**INDEPENDENT
ADVISORY PANEL FOR
UNDERGROUND MINING**

**DENDROBIUM EXTENSION
PROJECT**

SSD-8194

October 2020

Figure 2.2
Proposed Dendrobium Mine Layout

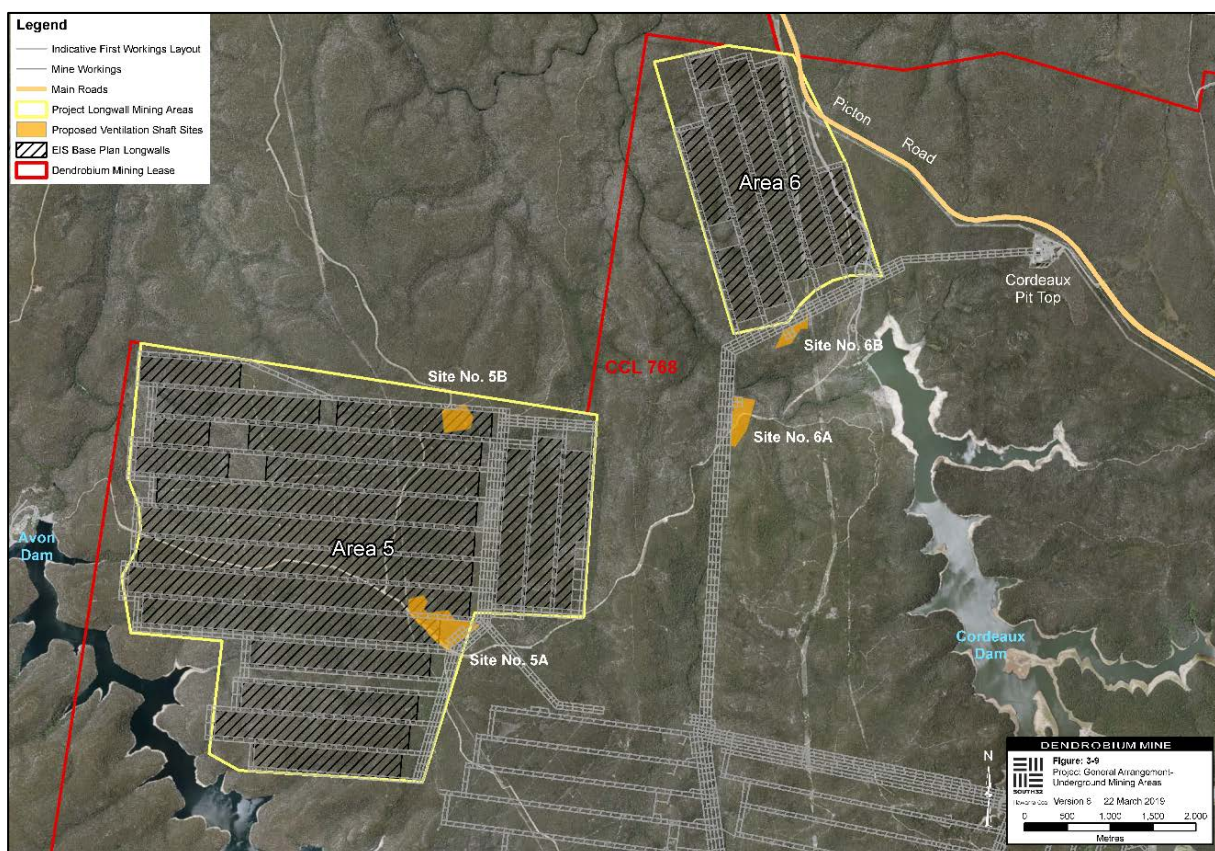
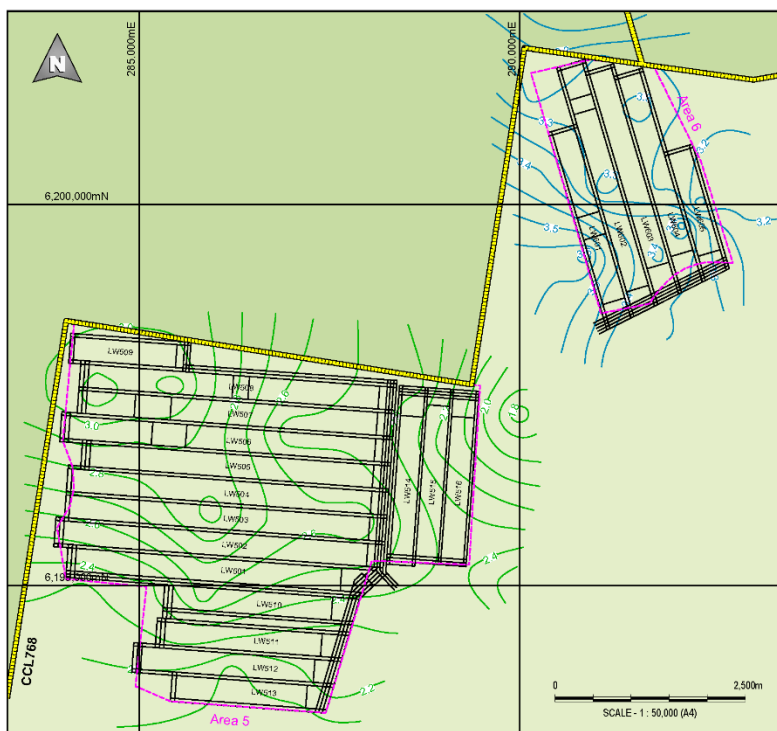
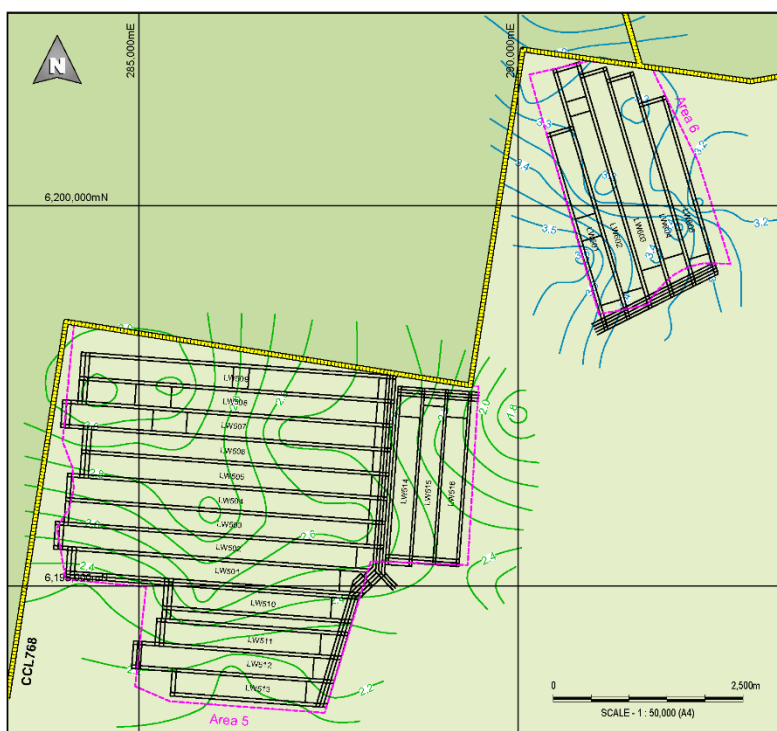
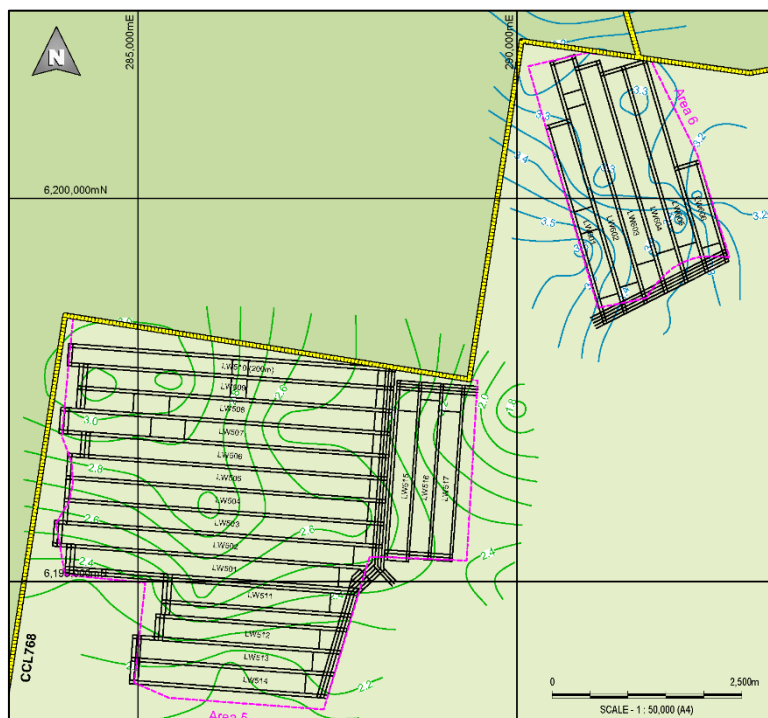
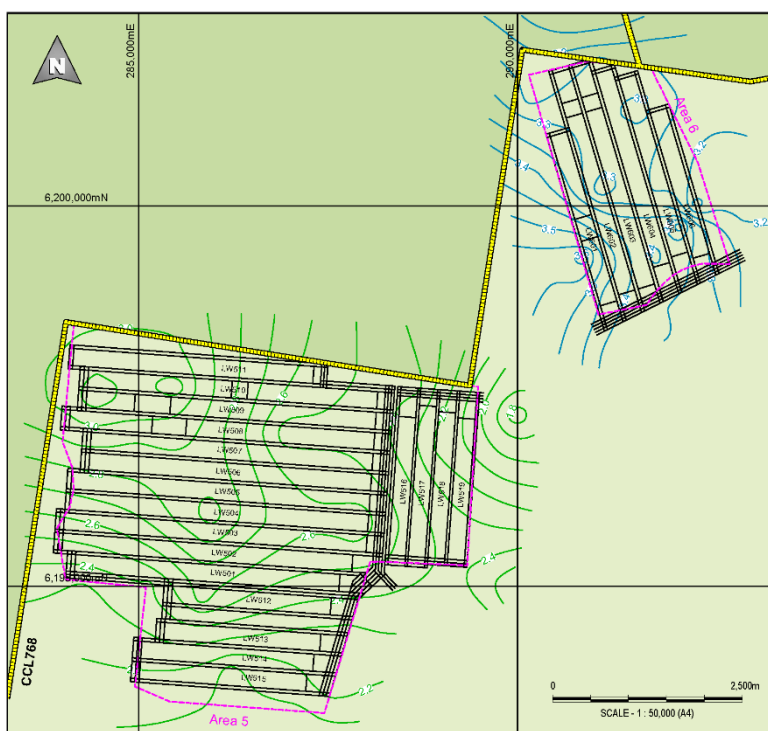
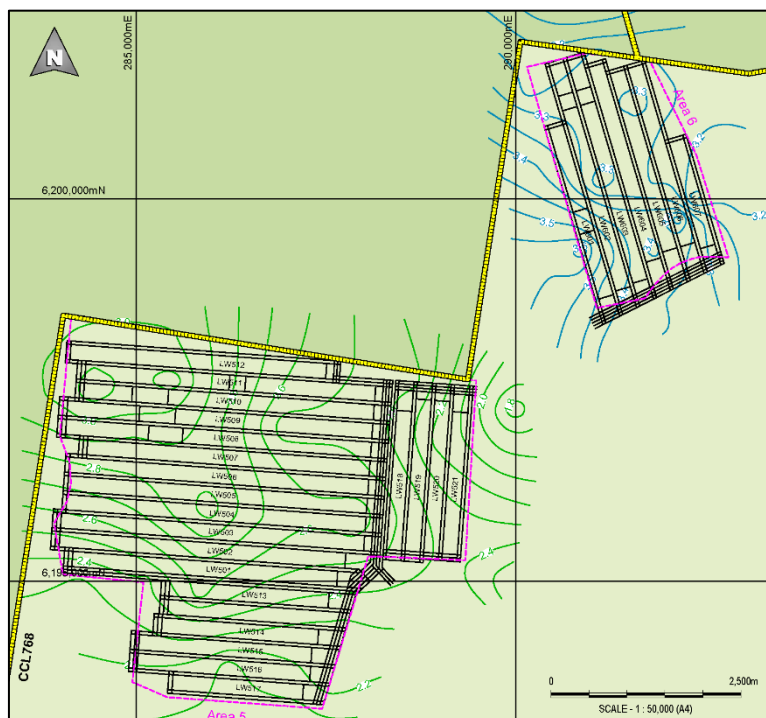
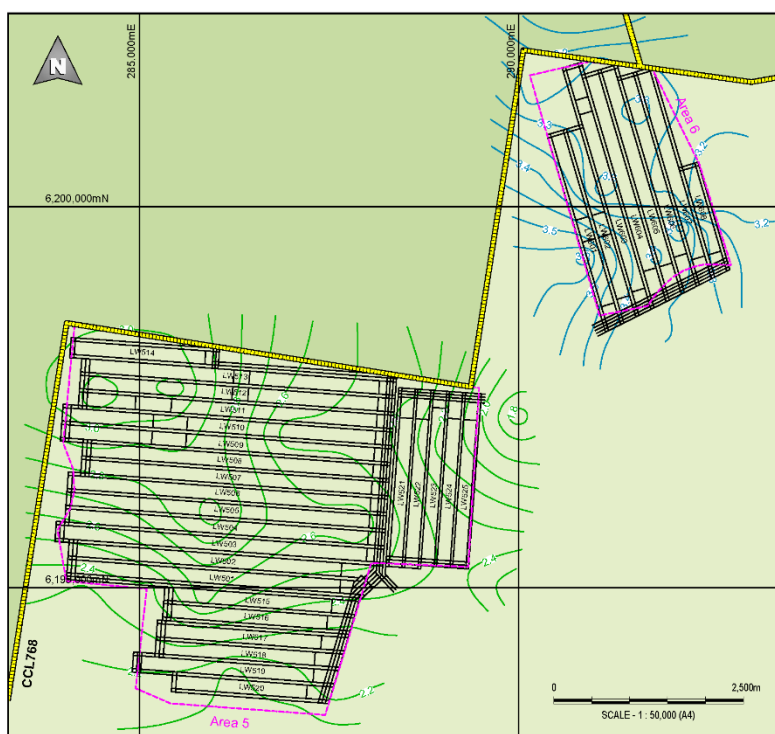
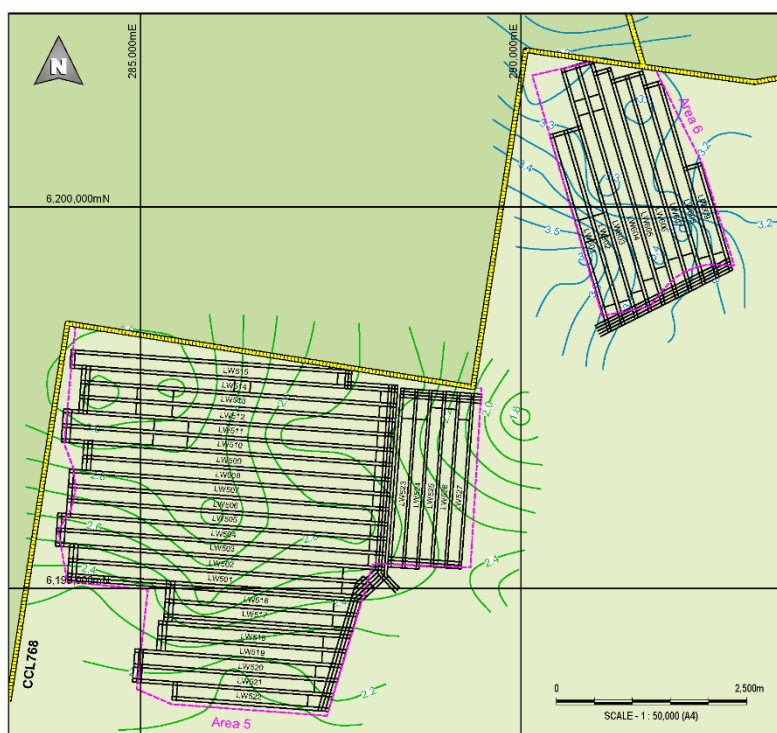
It is well established that mining panel width, height of extraction and depth of mining are important factors in determining the environmental impacts of mining-induced subsurface and surface ground subsidence. The EIS does not include any substantive sensitivity analysis of the influence of longwall panel width or mining height on subsidence effects, impacts and consequences. Nearly all longwall panel widths continue to be 305 m. The surface and groundwater assessments in the EIS are based on assuming a worst case outcome, being that the deep subsurface connective fracture zone will overlap with the shallow near-surface connective fracture zone to result in connective fracturing from the mine workings through to the surface over the mine workings in Areas 5 and 6. No justification on technical or environmental grounds has been provided for panel widths of 305 m, with the Panel being advised by the Proponent that it is based on experience with this width at Dendrobium Mine and economic returns.

1. At Dendrobium Mine, longwall panel width is not the key control when considering environmental impacts on natural surface features due to mining-induced non-conventional subsidence, in particular, valley closure. This is because environmental impacts due to non-conventional surface subsidence start to plateau at longwall panel widths that are reported to be too narrow to be economic at Dendrobium Mine.

16. The subsidence assessment of mining layout options does not provide a basis for assessing the sensitivity of environmental impacts and consequences to setback distances from natural features; longwall panel width; longwall extraction height; and longwall panel orientation.
